Report following a request for further information or negotiation

REF NO: FG/16/12/

LOCATION: Country Fayre
Littlehampton Road
Ferring

PROPOSAL: Application for a Minor Material Amendment following a grant of planning permission FG/33/10/ for minor alterations to elevations of building, including lobby, energy centre & plant. Minor alterations to car park layout, landscaping & surface materials (this application also falls within the parish of Angmering)

New enclosed entrance lobby

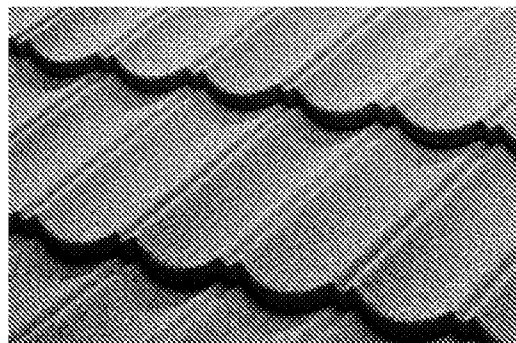
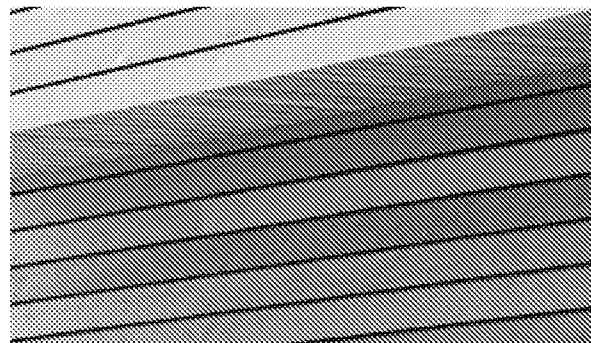
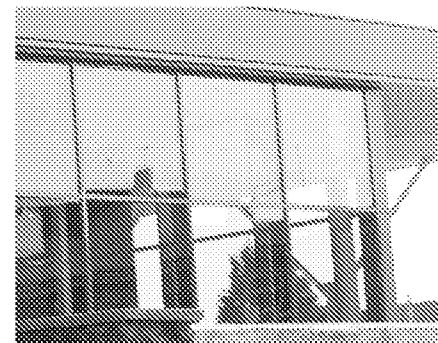
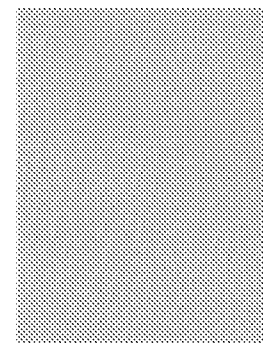
Lobby Area - this appears to be a potential increase in floor space as set down in Condition 3 of the Decision Notice and therefore the Parish Council objects.

New entrance lobby will increase the overall floor space of the site.

It can be seen that in the case of this application the scale of the development has not changed significantly. Total floor area has increased by 65sq.m due to the new entrance lobby. However the floorspace allowed for retail sales, the retail split, and range of good that can be sold have not changed and remain restricted by Condition 2. The number of parking spaces available has increased by 4. As such the scale of the development has not changed in a significant way.

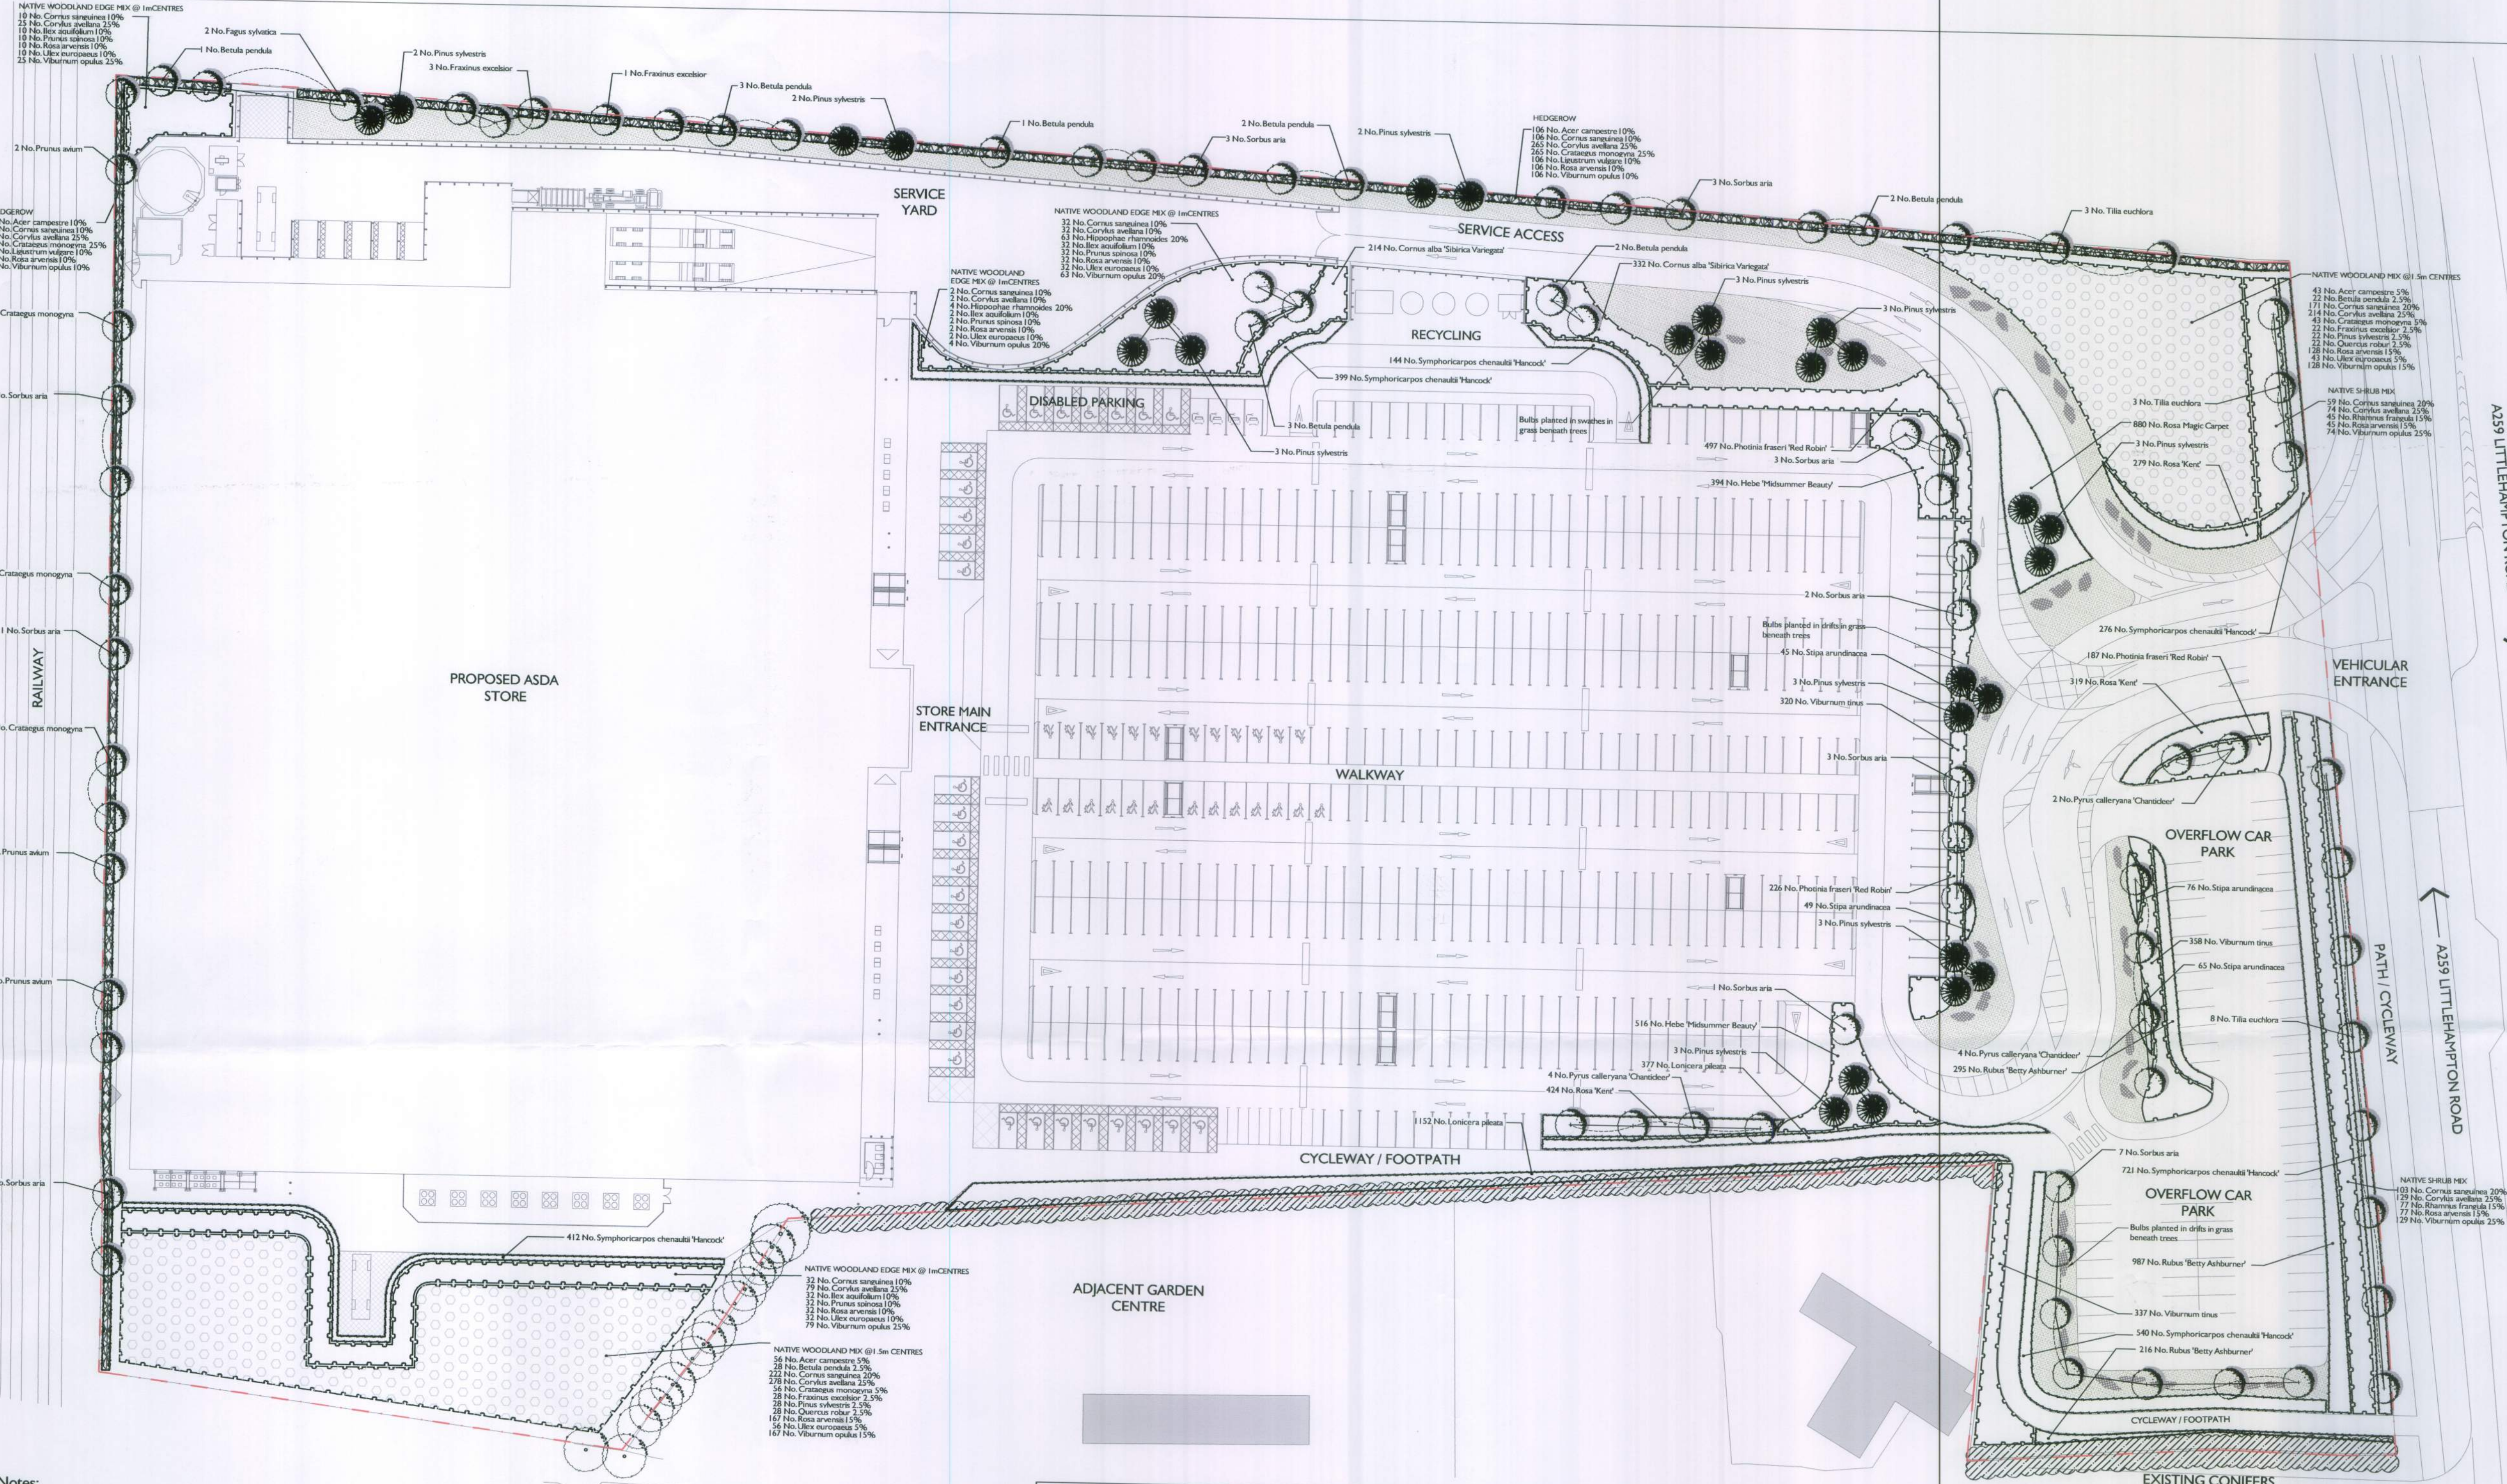
The applicants submitted a detailed landscaping scheme as requested. The submitted plan provided further information on the species of plants proposed, the height of species when planted and density of planting. Proposed trees measure 450cm tall.

The planting on the western boundary of the site has been increased and they are proposing to plant some wider spreading trees at the southern end of the site adjacent to the building where the verge is wider. They have also proposed a substantial landscaped border on the eastern side of the service road which is in addition to the original approved schemes.

The detailed landscape scheme has been evaluated by the District Councils Trees and Landscape Manager who made a number of detailed comments regarding the species and mix of planting. The Trees and Landscape Manager has concluded that the proposed landscape scheme would be acceptable and has not raised an objection.
